Re: Homewood Suites
5400 San Antonio Dr. NE
Request for Certificate of Occupancy
Transportation Development Final Inspection
Engineer's/Architect's Stamp dated 4-11-18 (E15D050)
Certification dated 8-28-19

Based upon the information provided in your submittal received 8-28-19, Transportation Development cannot approve the release of Certificate of Occupancy for the above referenced project.

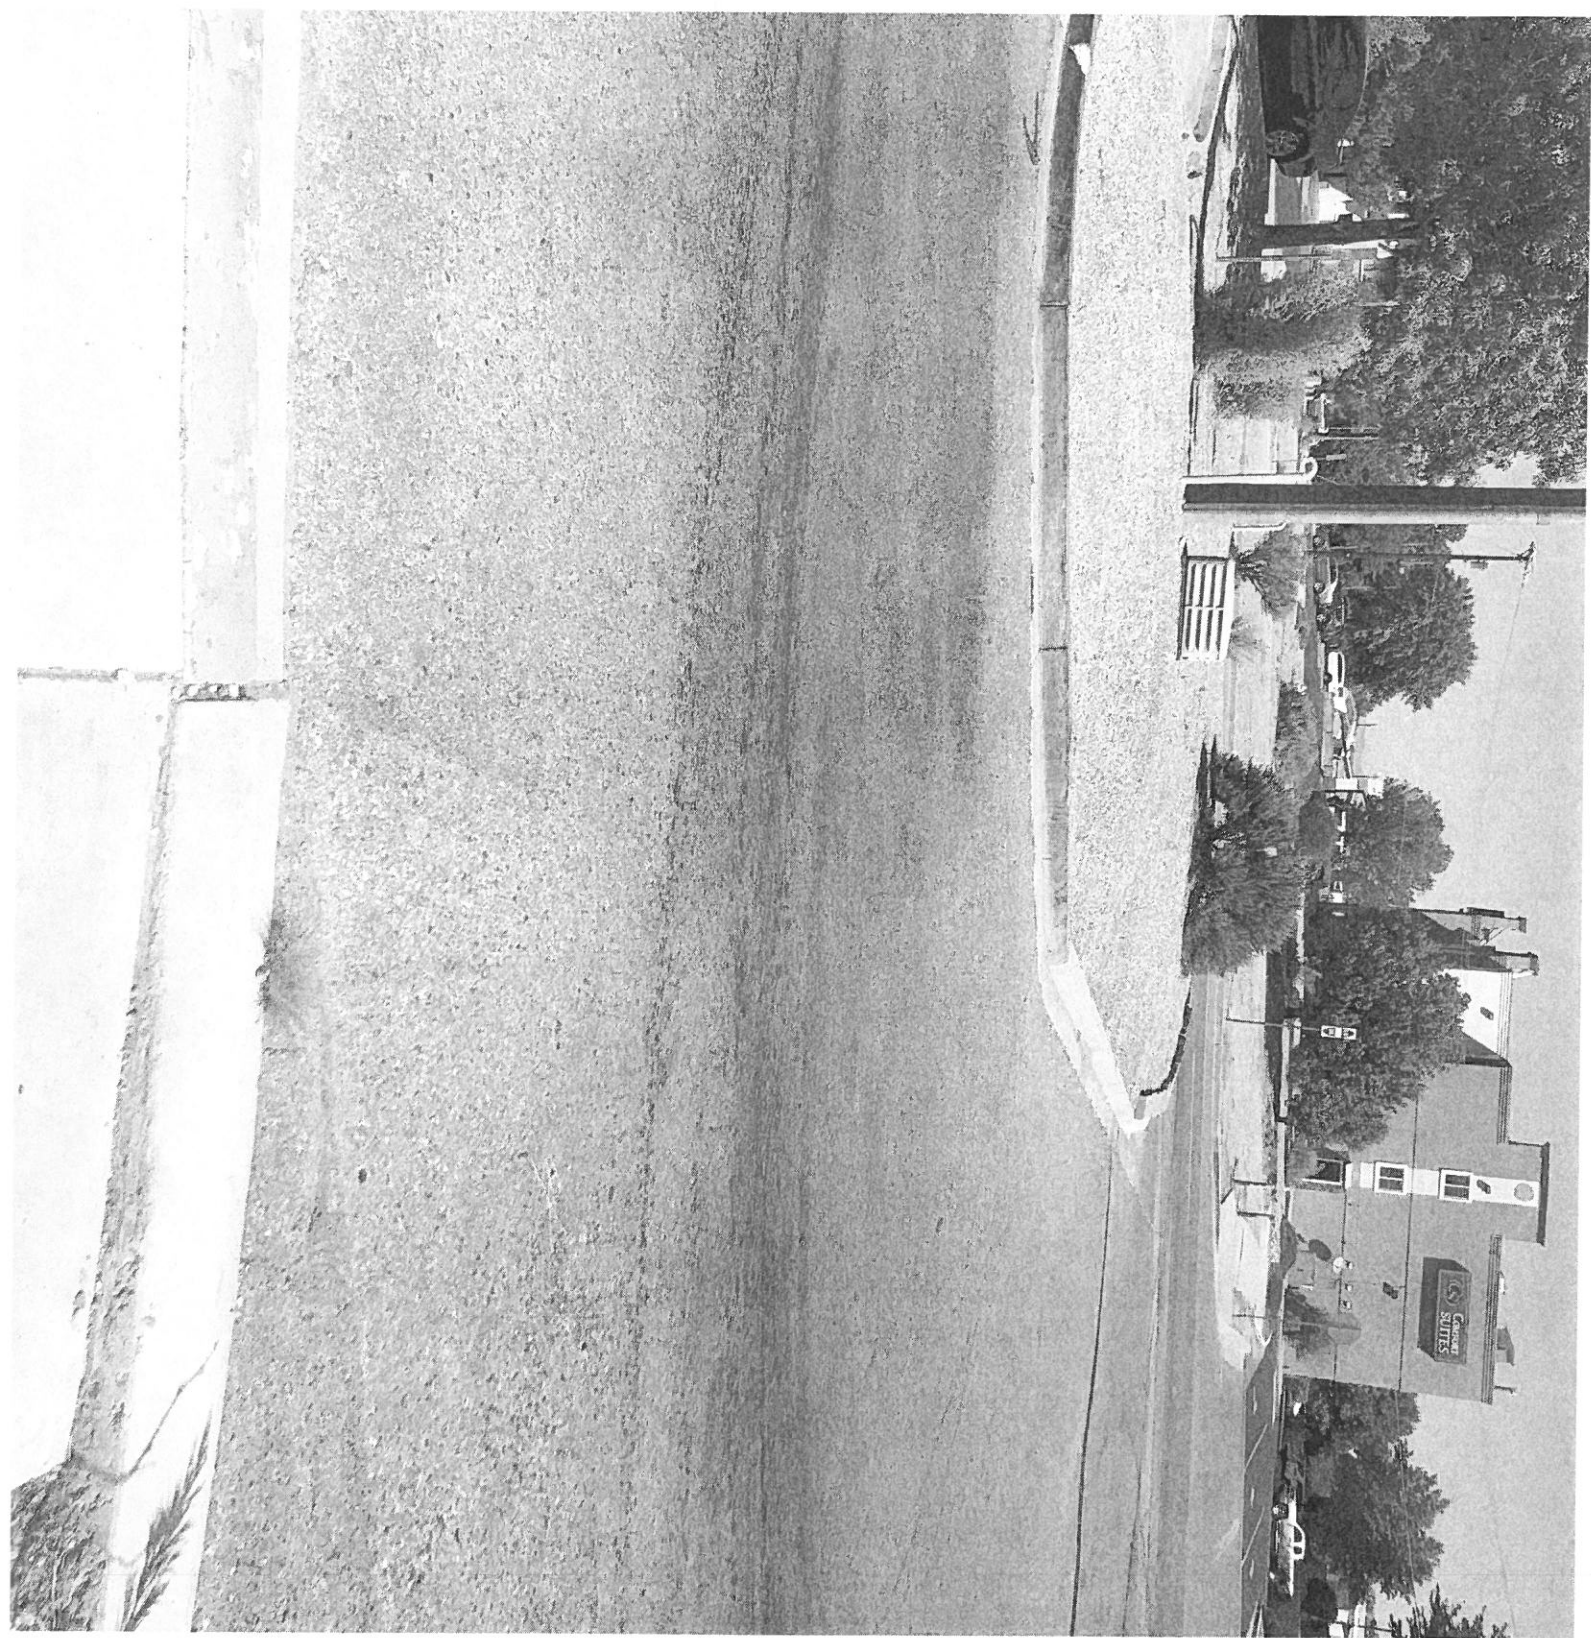
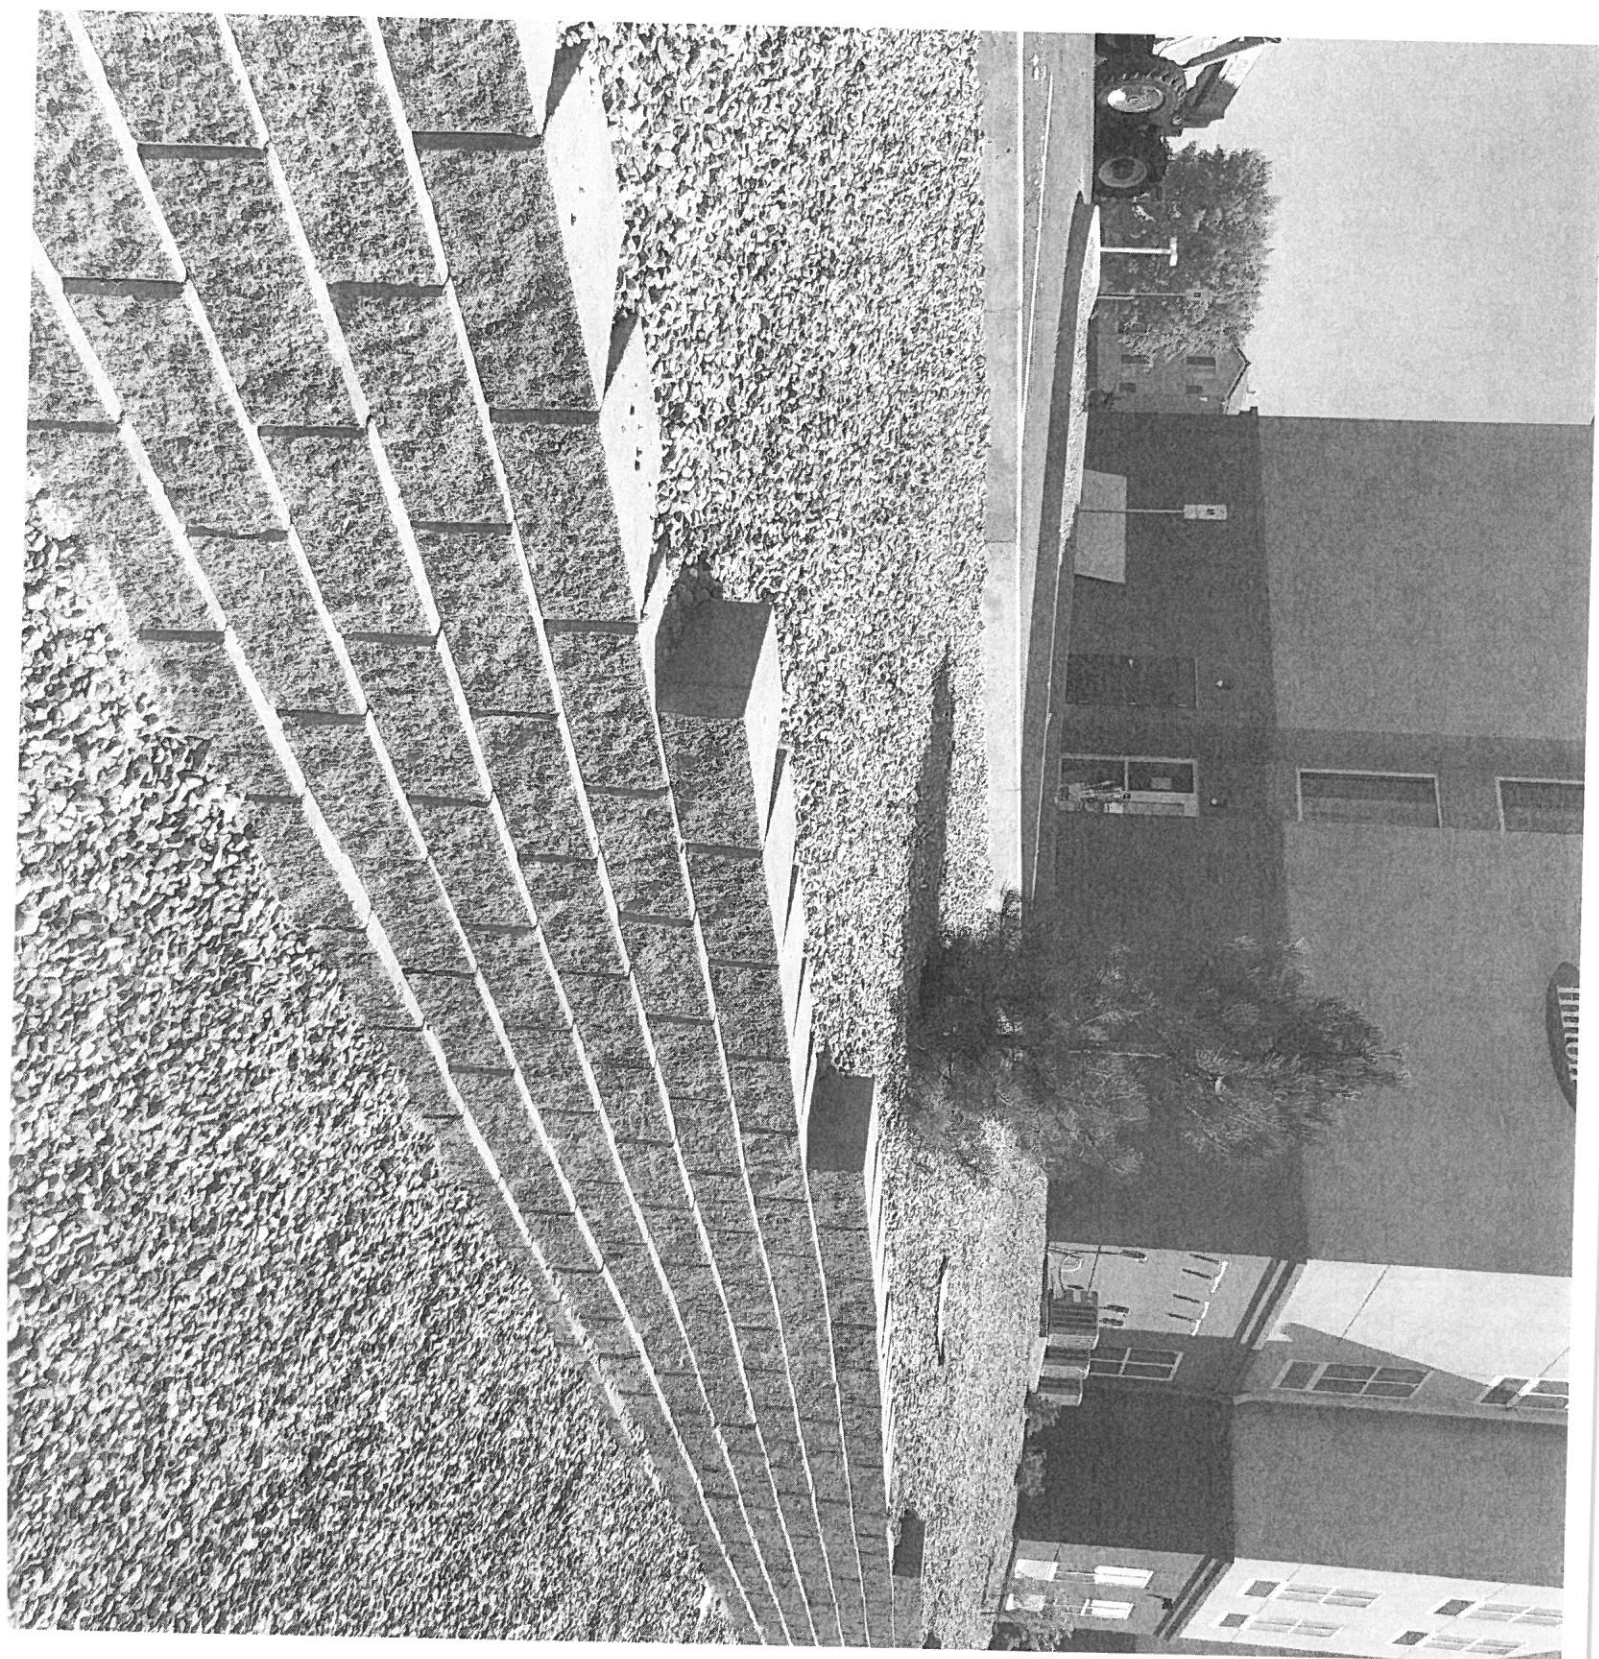
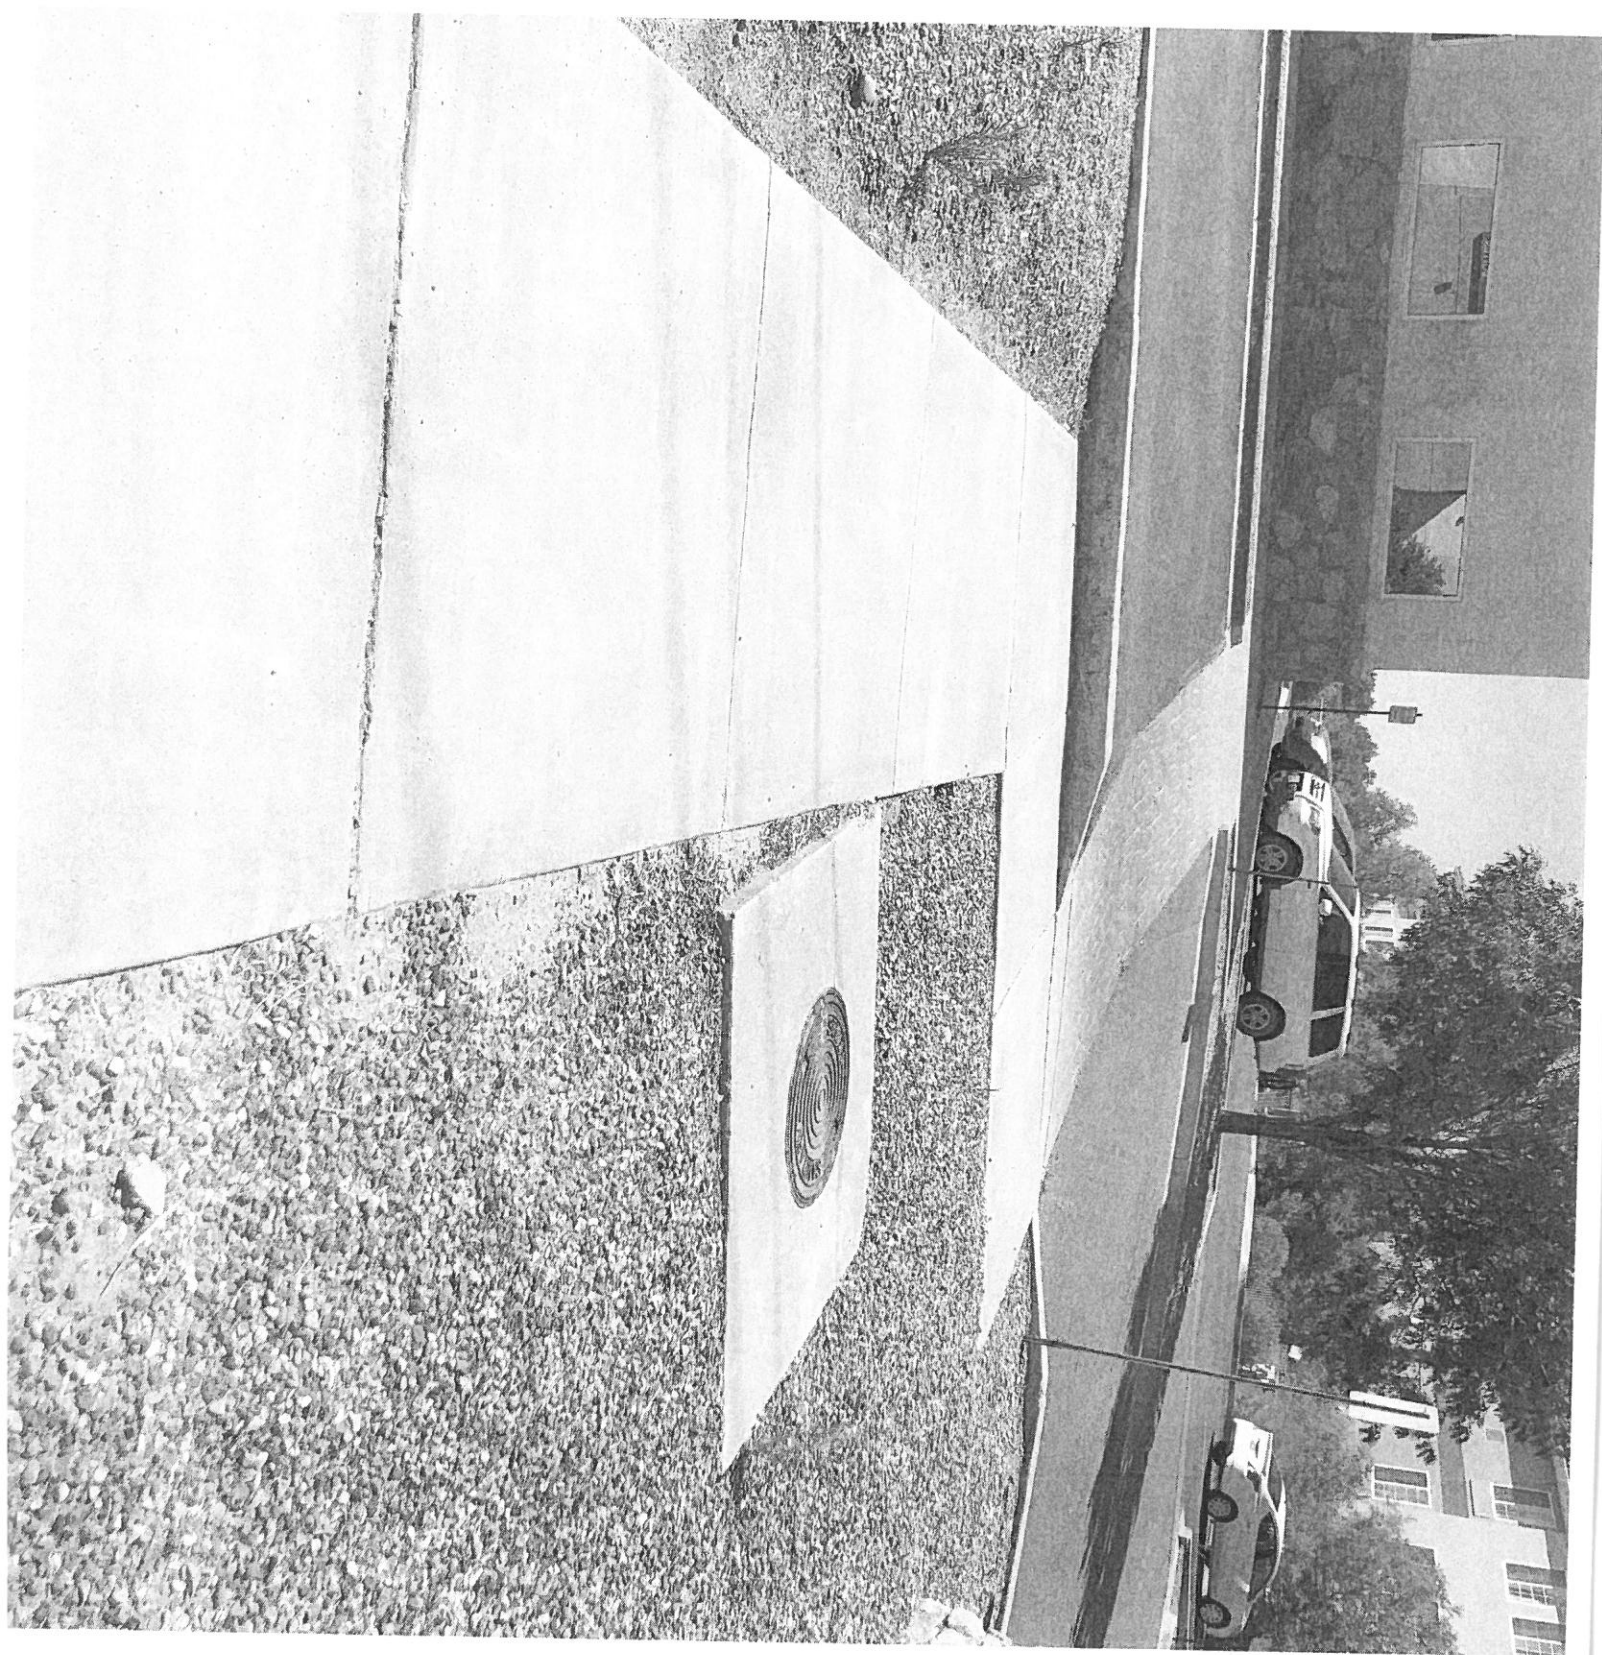
- Add 6ft wide ADA accessible pedestrian pathway from sidewalk to building entrance. Missing ramps and sidewalk. Refer to approved DRB site plan.
- Add missing motorcycle stalls and signs.
- Add missing ADA signs. Stalls located next to Patio.
- Please correct ramp leading to existing building. Ramp has 1" lip not allowing wheelchair access.
- Add sidewalk connecting to path along channel. Refer to approved DRB site Plan.
- Add bollards to parking stall on NW corner. Refer to approved Grading & Drainage Plan. Attach is the section of the Grading Plan indicating the barrier.
- Attached is the DRB Site Plan. Circled in RED are the areas of corrections.
